M42 Junction 6 Development Consent Order

Scheme Number TR010027

8.16(a) Statement of Common Ground with National Exhibition Centre Limited

October 2019

Drawing Title
**FIGURE 3.8
CADENT GAS DIVERSION
AND PROTECTION WORKS
SHEET 3 OF 3**

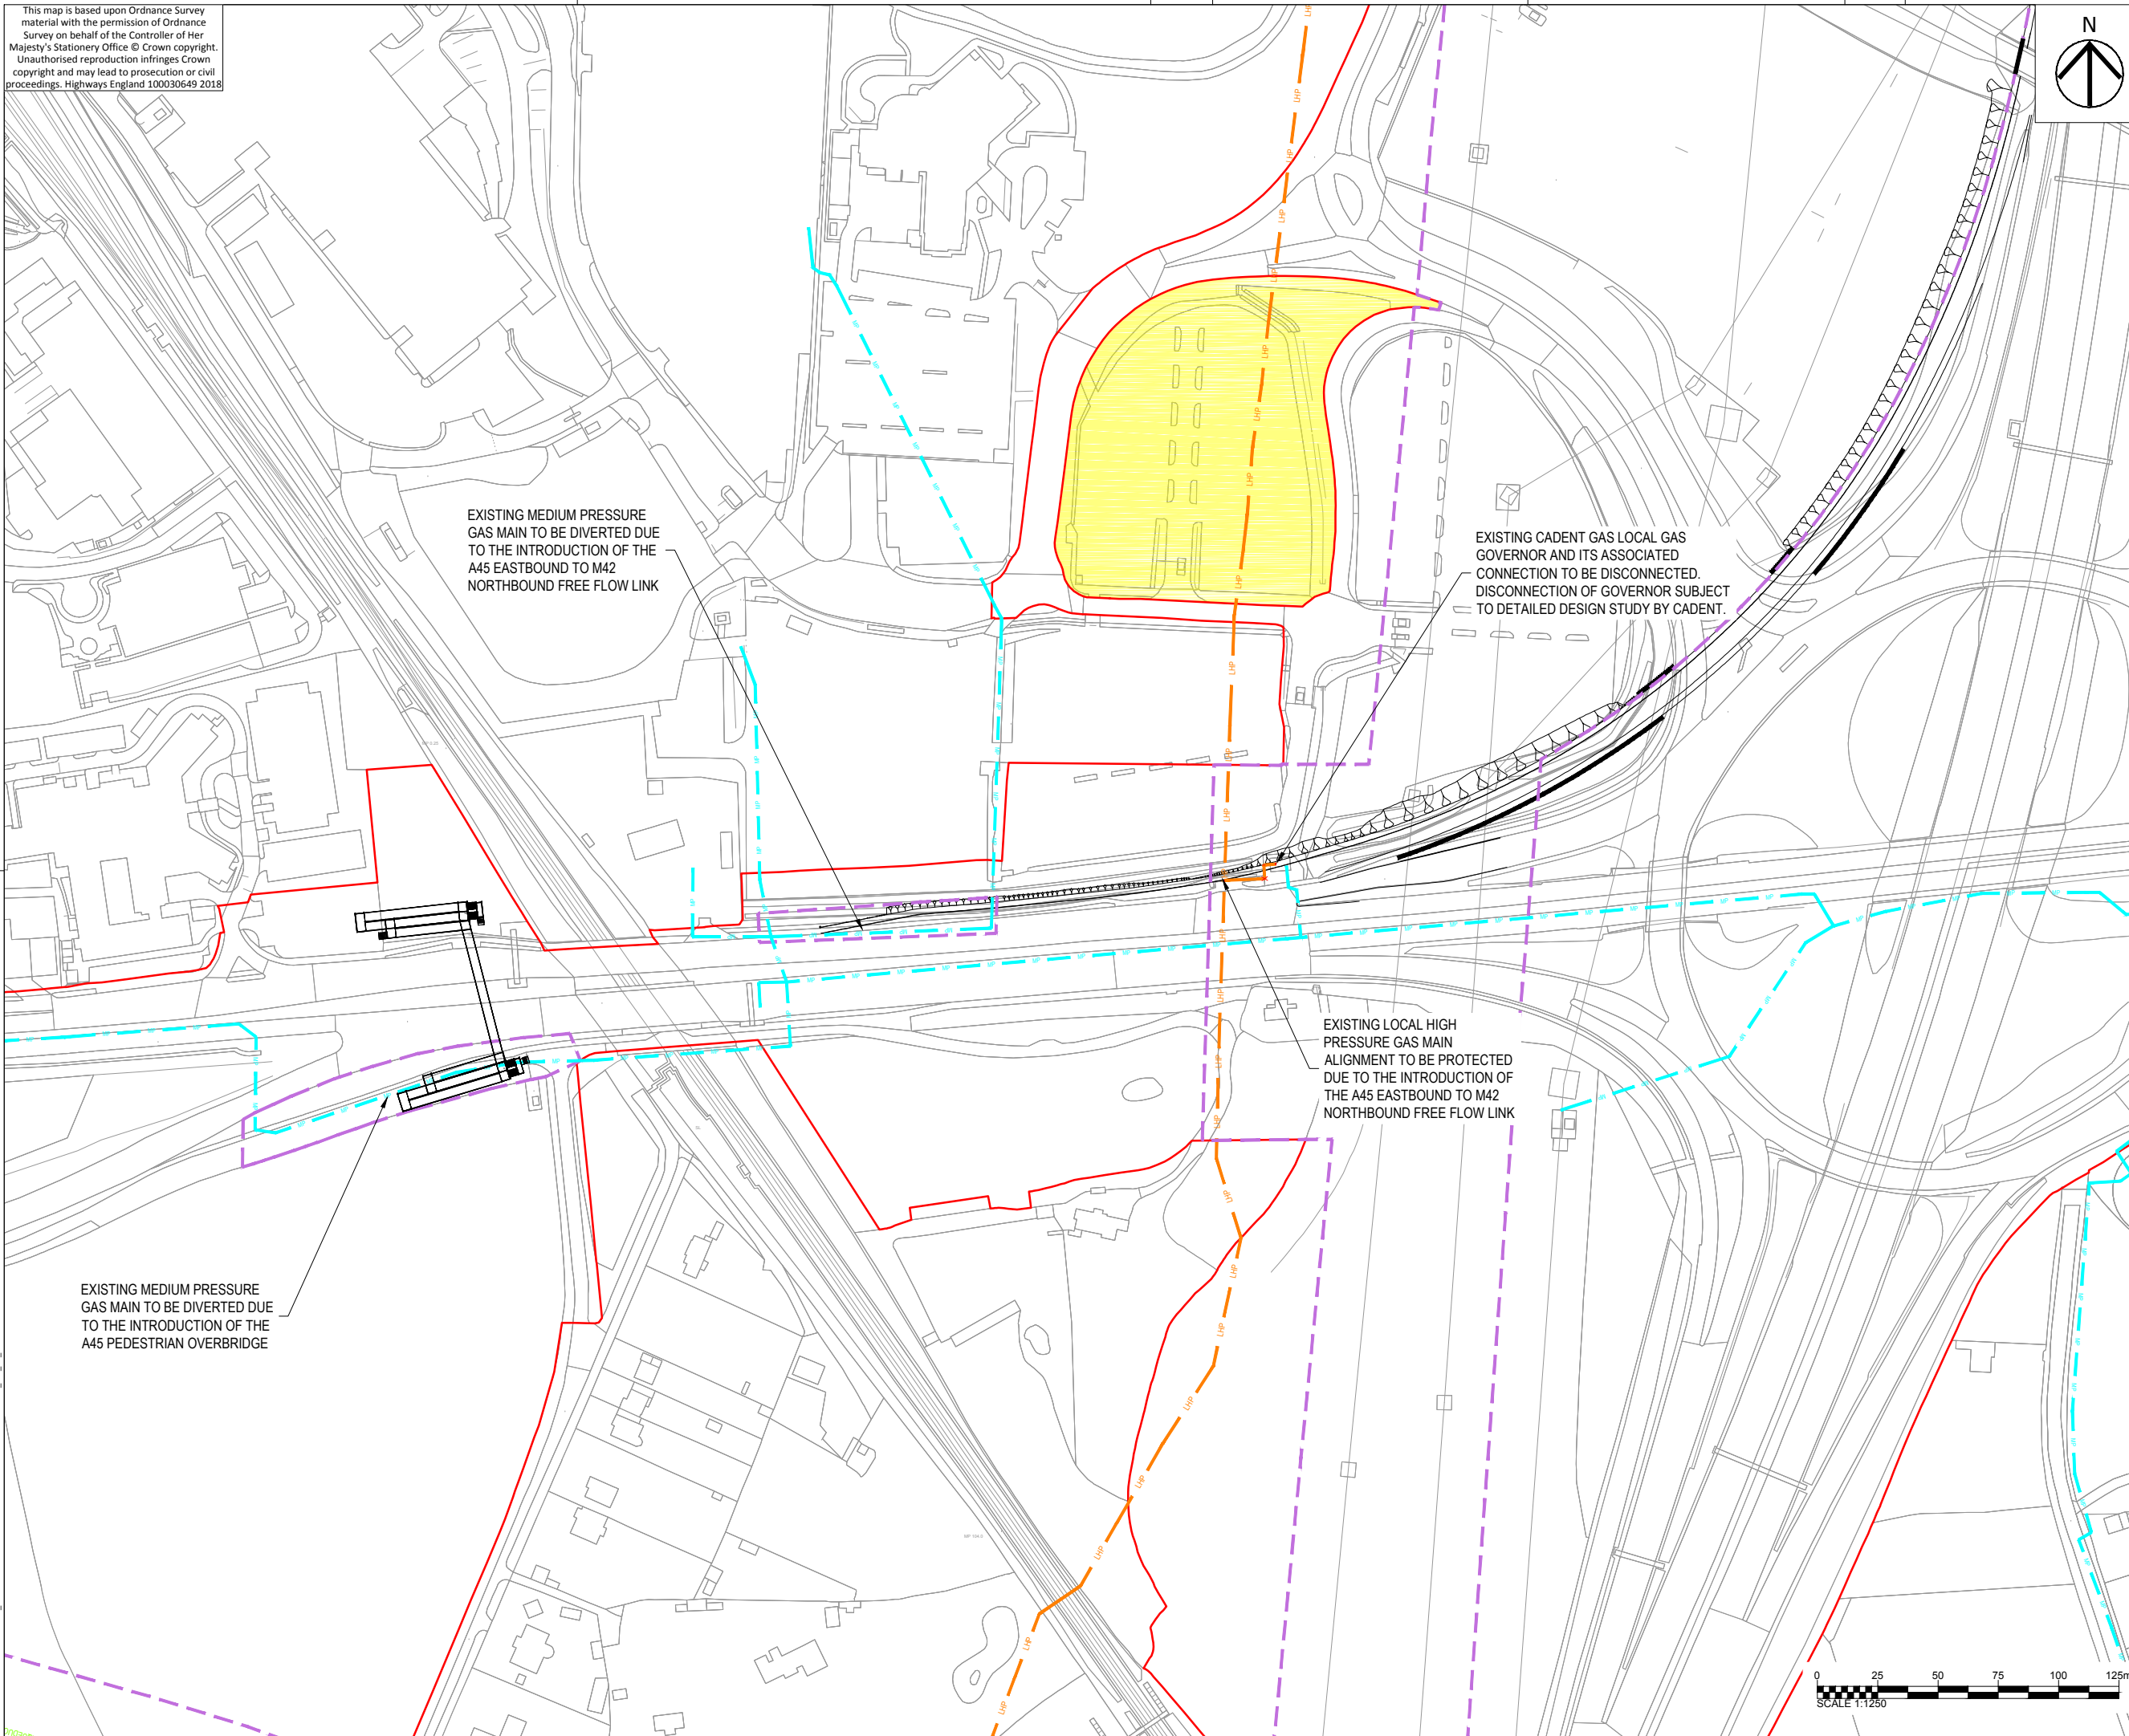
Sub-topic	NEC Comment	Highways England Response/Actions	Status/Agreement
<p>Gas governor</p>	<p>The NEC queried whether the gas and electricity apparatus was to be impacted by the Scheme.</p>	<p>It was previously expected that Cadent Gas would decommission its gas governor in the vicinity of the NEC.</p> <p>During recent discussions, Cadent Gas has advised that it will be retaining the governor and is therefore considering alternative locations for this to be situated. Discussions are underway with Cadent Gas to relocate the governor within the DCO powers and Order limits.</p> <p>In acknowledgement of the potential impact on the NEC's car parks, Highways England will use reasonable endeavours to ensure that Cadent Gas pursues the relocation of its gas governor as a result of the Scheme either off-site or outside of the NEC's retained land.</p>	<p>Under Discussion</p>
